Application No: BN/96/25/PL
Site Address: Land West of Brookside Highground Lane
Description of works: Demolition of existing barn to be replaced by a new barn within the existing footprint. This application is in CIL zone 3 (zero rated) as other development. This may affect the character and appearance of the Church Lane, Barnham Conservation Area.

Objection to Planning Application BN/96/25/PL

**PROPOSED PLAN & ELEVATIONS -
BARN**

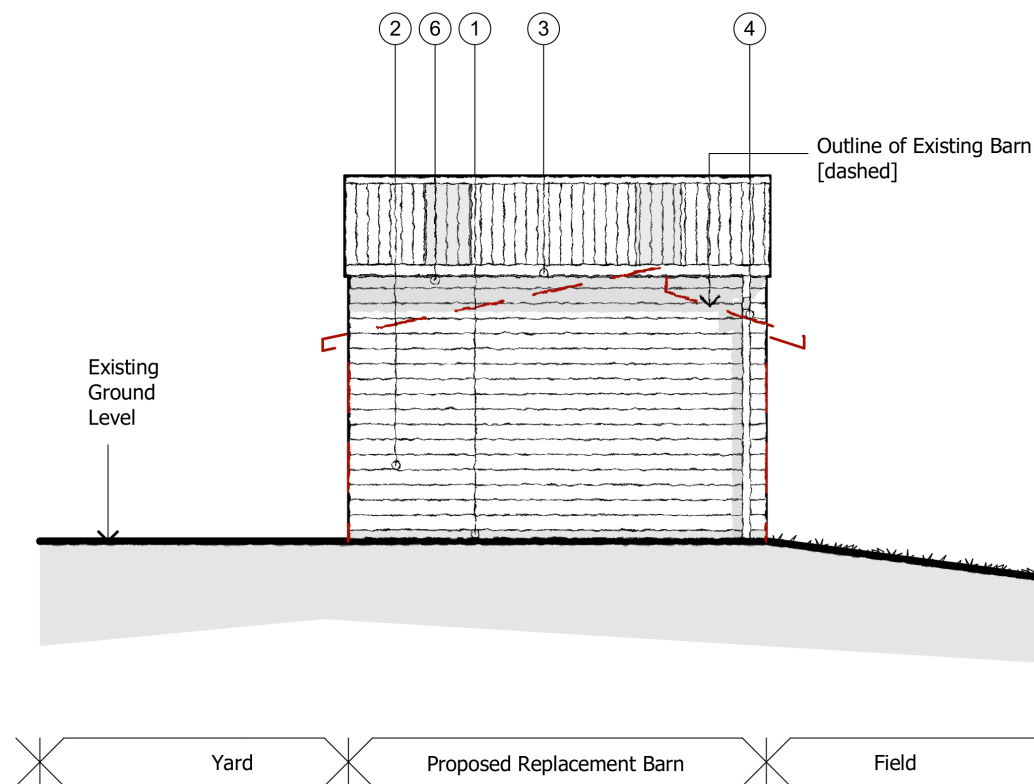
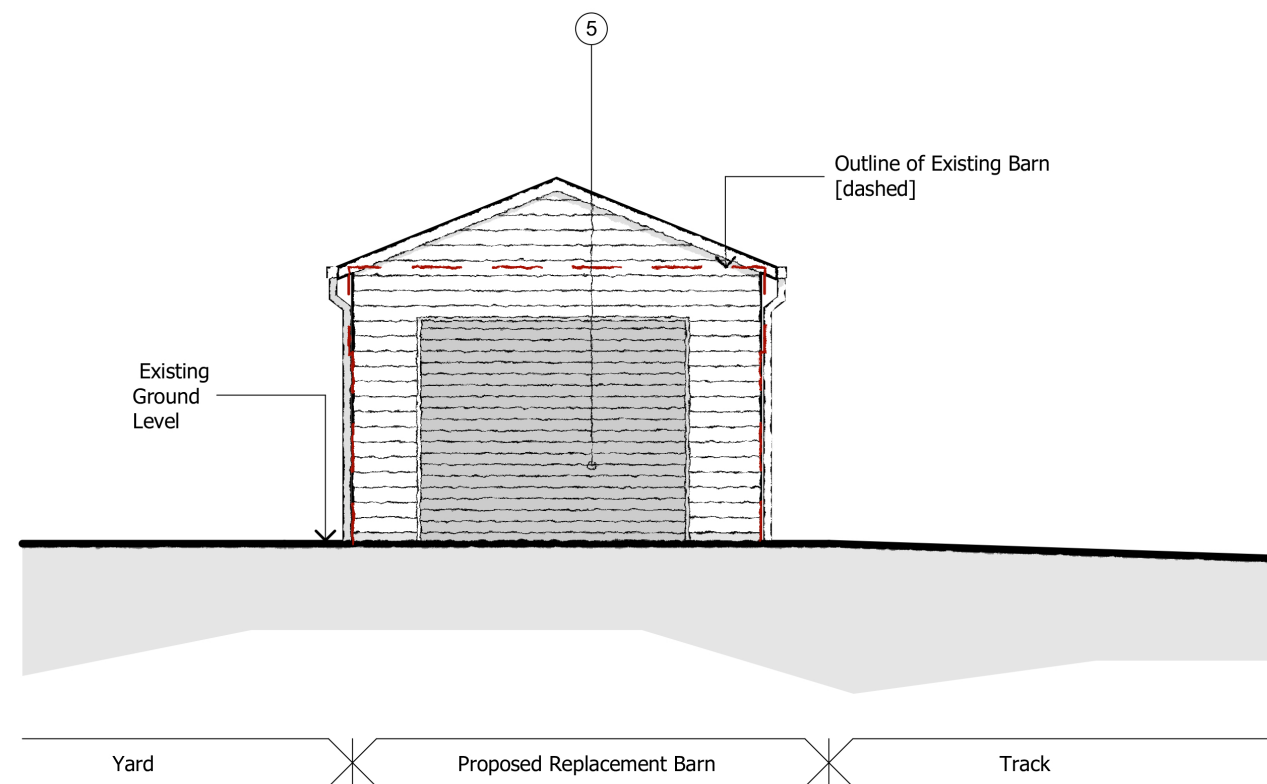
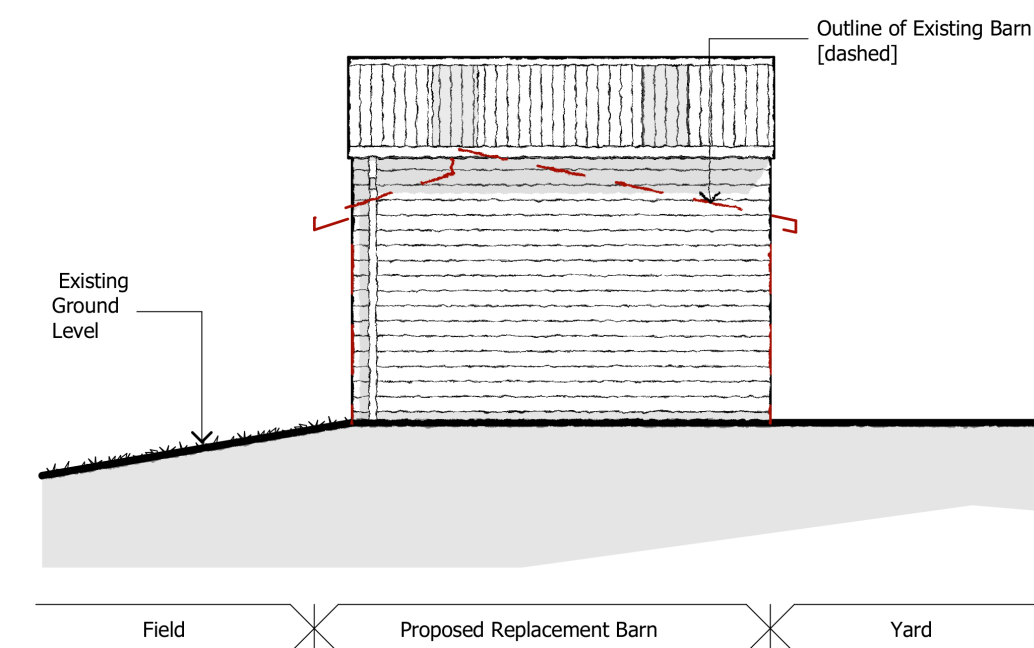
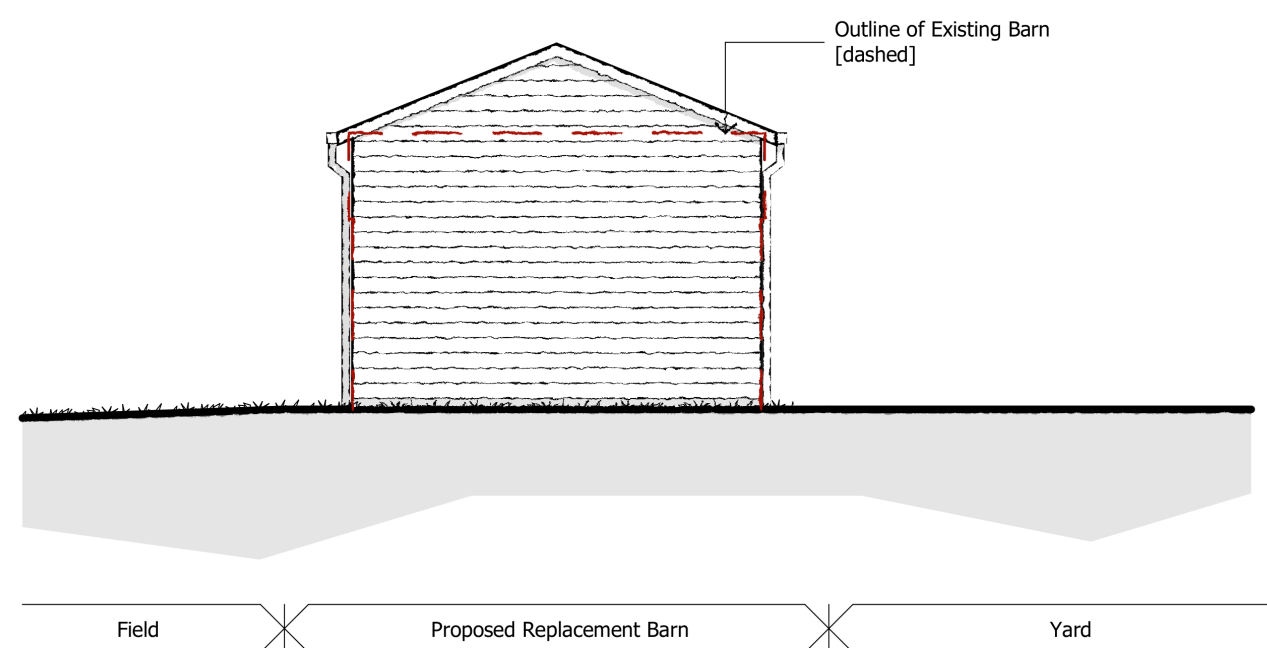
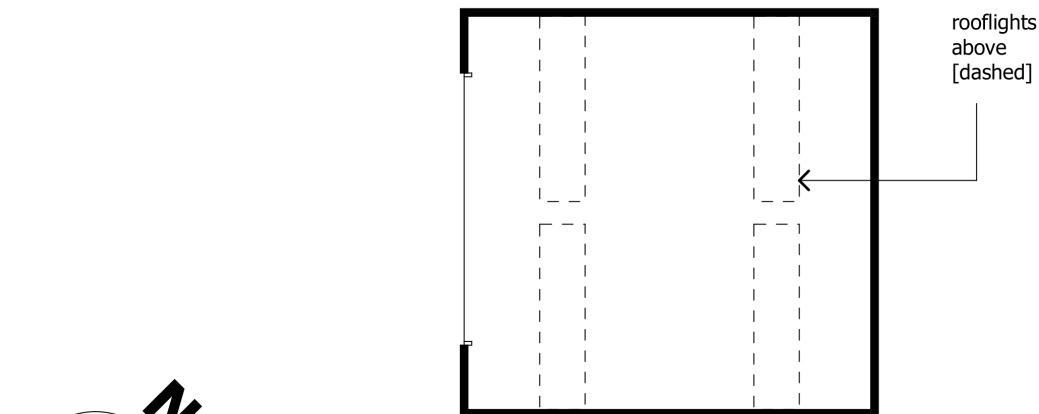
It has been indicated the proposed structure will have roof lights which may increase light pollution in the immediate area. If it is intended these lights be on permanently at night, this will impact the vista and character of the immediate area and cause a nuisance to neighbouring residents.

Above: Flood Risk Map - Environment Agency 2025

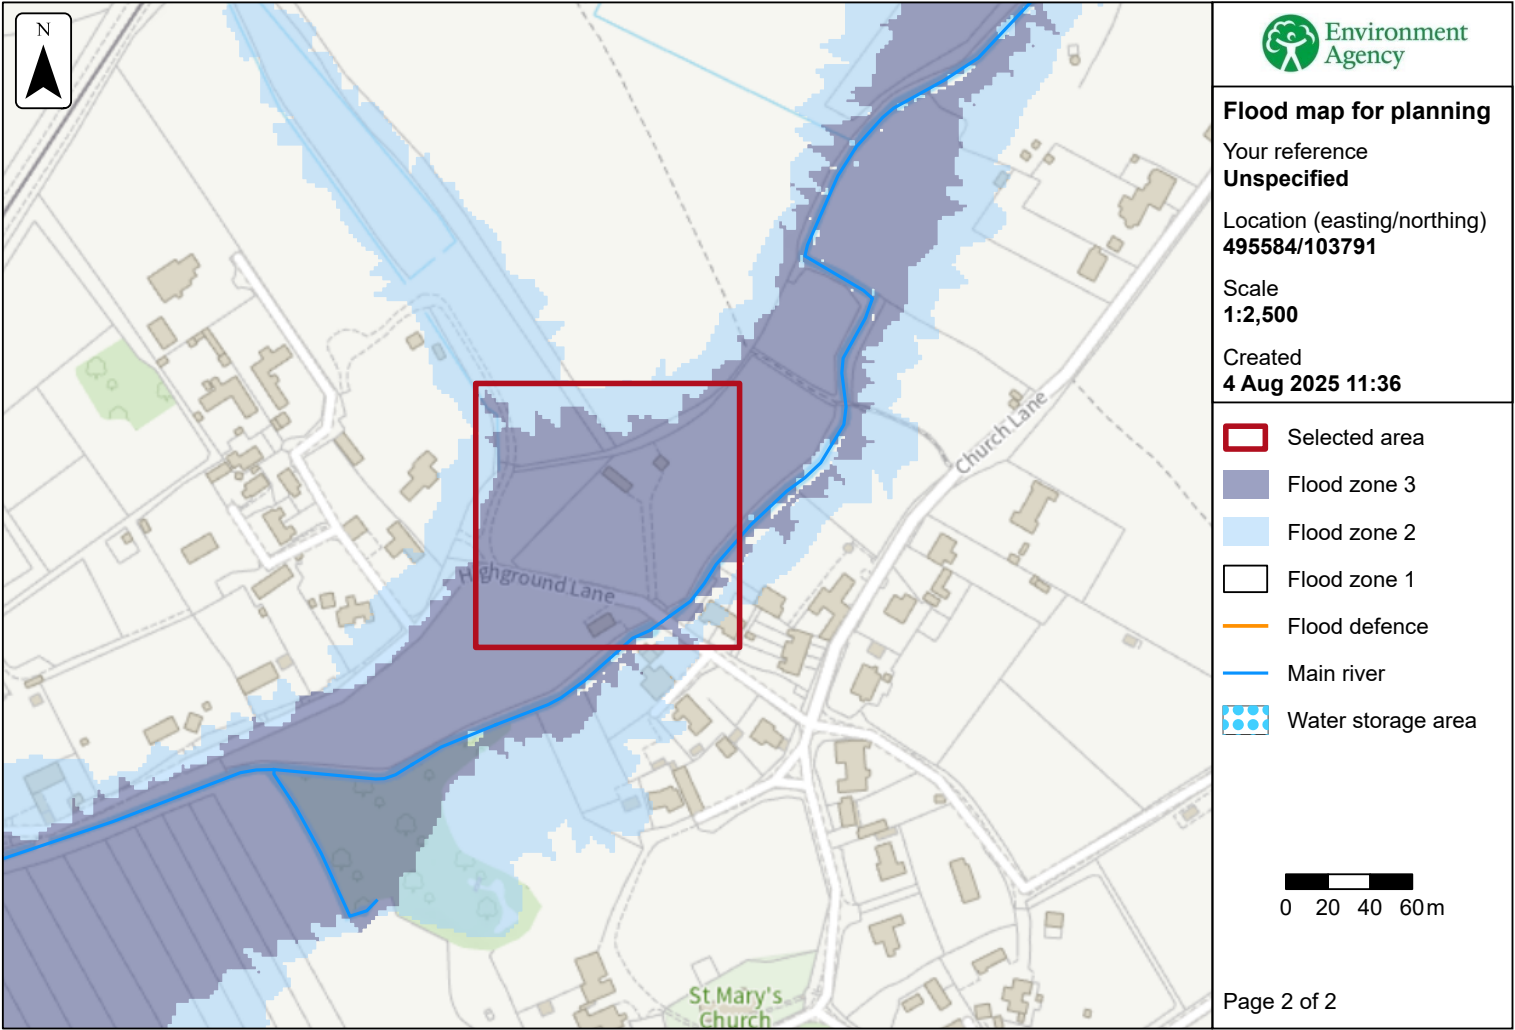
The proposed site is located within Flood Zone 3b, being a functional floodplain, where water has to flow or be stored in times of flood. This particular area is prone to frequent flooding and is therefore an inappropriate location for the proposed structure, with development on such areas being restricted to water-compatible development, which does not include structures such as that being proposed.
